CHANGE REQUEST AND CONSULTATION REPORT: 9.6

Cory Decarbonisation Project

PINS Reference: EN010128

October 2024

FRONT ELEVATION
SCALE 1:500

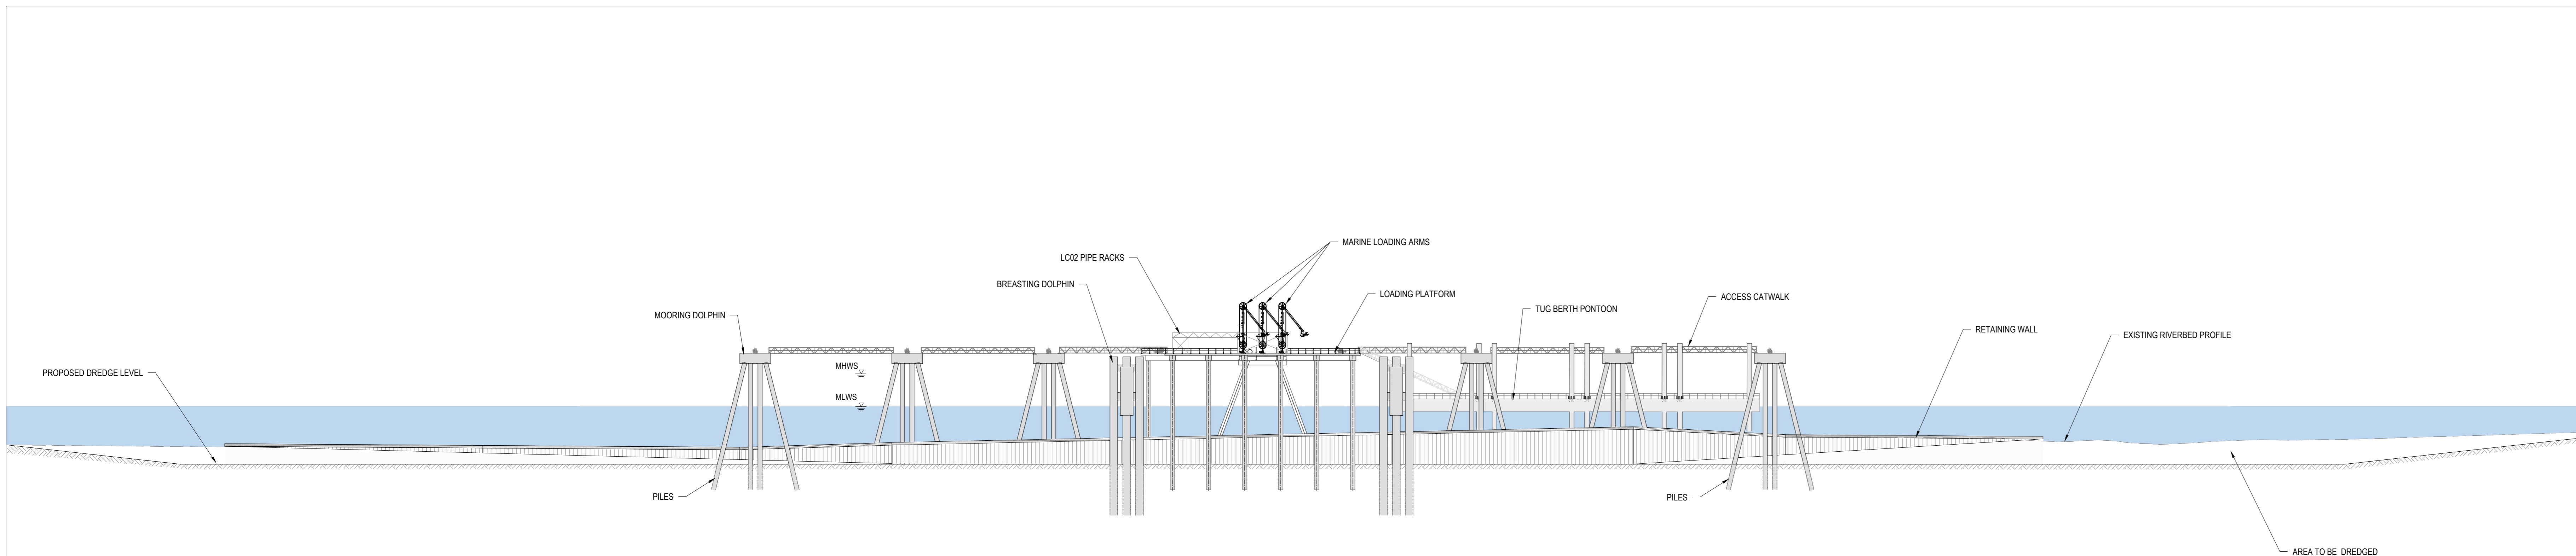
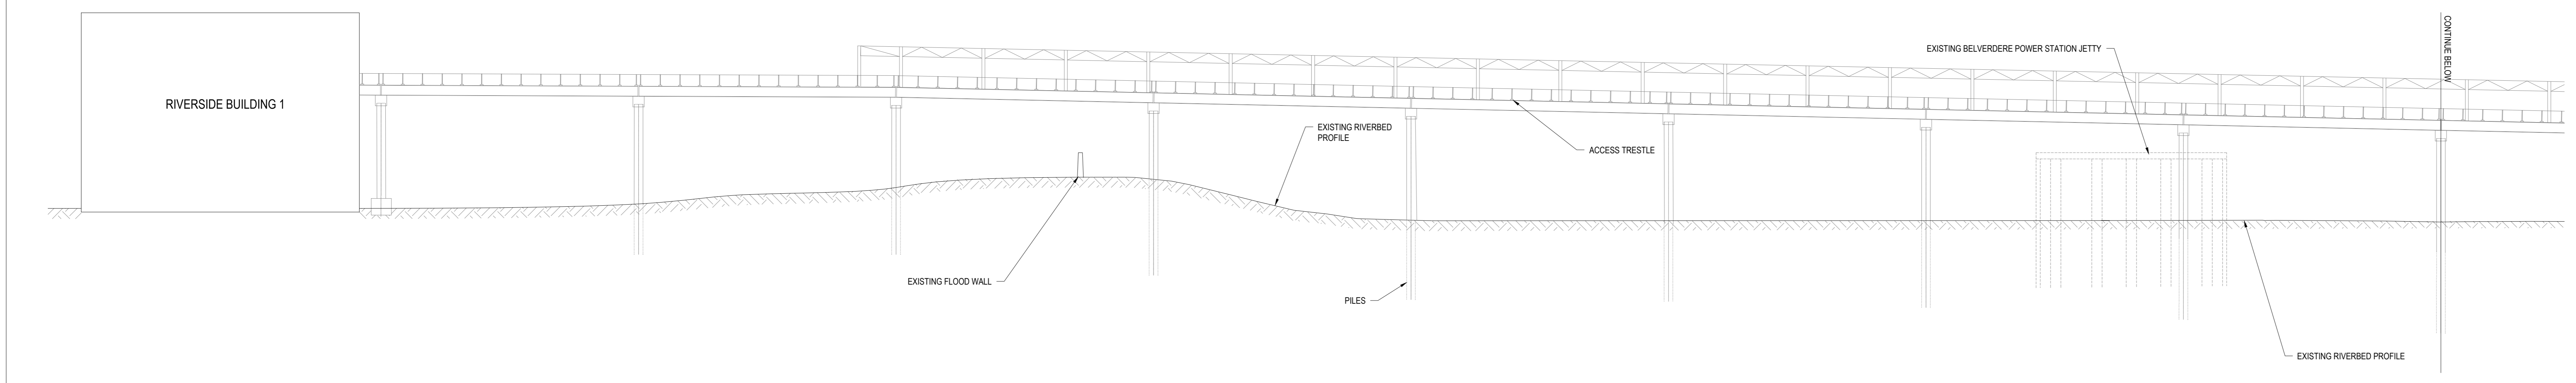
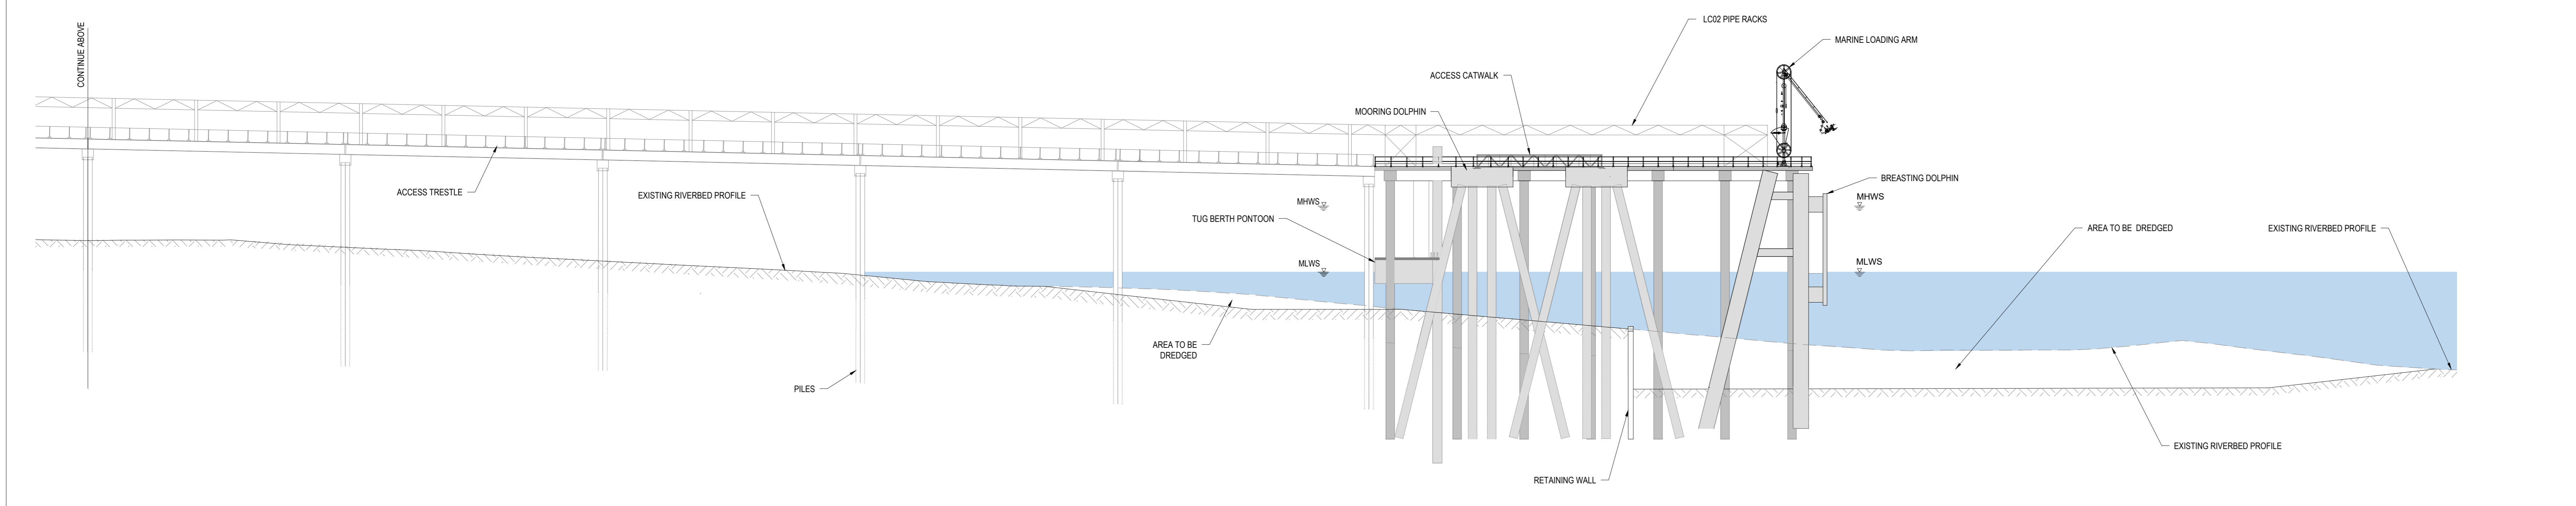
2.1.7. Articles 2, 13, and Schedule 16 of the **draft DCO (AS-014)** and the limits of deviation shown on Work No. 4 the **Works Plans (AS-007)** set out the maximum parameters for the Proposed Jetty. Facilitating vessels of approximately 20,000m³ would result in the following changes to these parameters:

- the downwards limits of deviation for dredging set out in article 2 of the draft DCO need to be increased from minus 10.50 chart datum to minus 11.00 chart datum to account for small tweaks in jetty design;
- there is an increase in the number of breasting dolphins from 2 to 4 in Schedule 16; and
- the slight reduction of the limits of deviation for Work No. 4B shown on the Works Plans.

- an increase in assumed capital dredging volume by approximately 40,000 m³; and
- a likely increase of the size of the sheet pile retaining wall either side of the dredge pocked by a combined approximately 70m.
